TRINITY HOUSE

21 August 2020

Your Ref: EN020022

**The Aquind Interconnector
Written Submission to Examining Authority
In Response to the Examining Authority First Round of Written Questions (ExQ1)
Issued on 3 July 2020 for Deadline 1**

File name \\UK.WSPGROUP.COM\CENTRAL DATA\PROJECTS\62100XXX\62100616 - AQUIND VO NO.3\IE MODELS AND DRAWINGS\300 - SITE\340 - TASK 9 MARINE ROUTE\CURRENT\ENVIRONMENTAL STATEMENT\UK\REV 1\FIGURE 3.1 UK MARINE CABLE CORRIDOR.DWG.

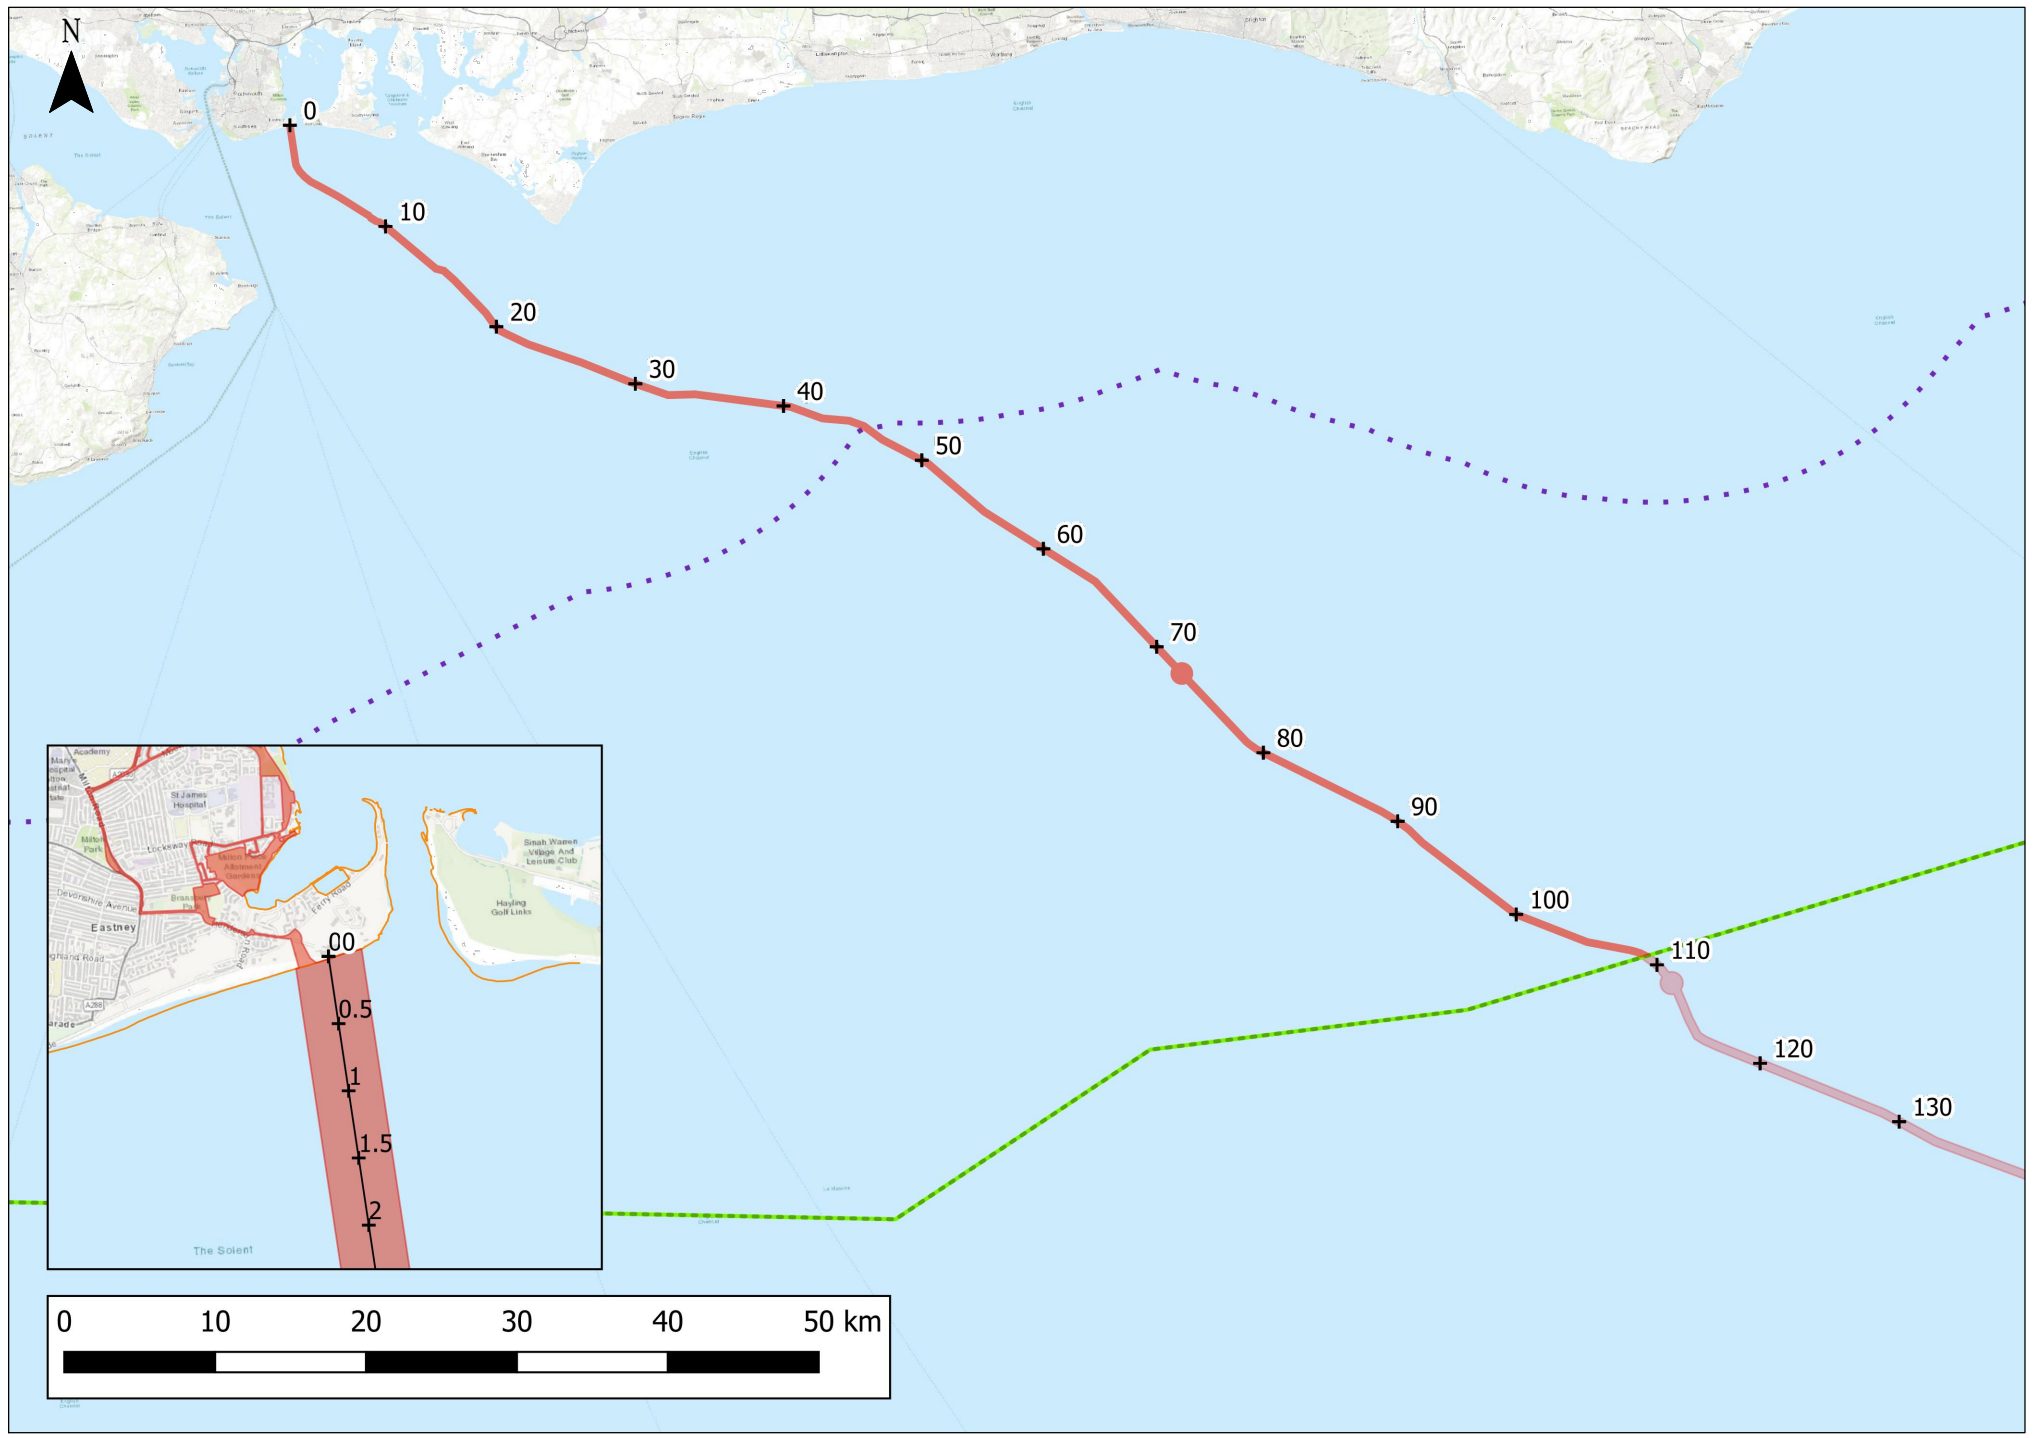
Trinity House would have concerns if any exclusion zones granted during the construction of the interconnector included areas within the Nab Channel. In particular, the proposed exclusion areas within the Nab Channel would reduce the navigable width of the channel and could have a serious impact on marine navigation. This would, therefore, need to be carefully managed and monitored by the relevant Port and Pilotage authorities, with the cooperation of the applicant.

The Nab East Pilot Boarding area for Southampton and Portsmouth would be affected if the construction area exclusion zones are used to restrict operations as vessels may require more room to manoeuvre, depending on the weather at the time. It is suggested that this

could be managed with good cooperation between the applicant and the Pilotage authorities as construction passes this area.

An exclusion zone around the construction operations may impact on vessels navigating outside of the Nab Channel, including recreational craft, although this should be mitigated by vessels complying with COLREGS and the proposed guard vessels.

Trinity House acknowledges that any exclusion zones, as described in ES Chapter 12, would be temporary during the construction phase and move accordingly. It is requested the applicant and relevant Port/harbour authorities promulgate appropriate information to the marine users in the area accordingly.
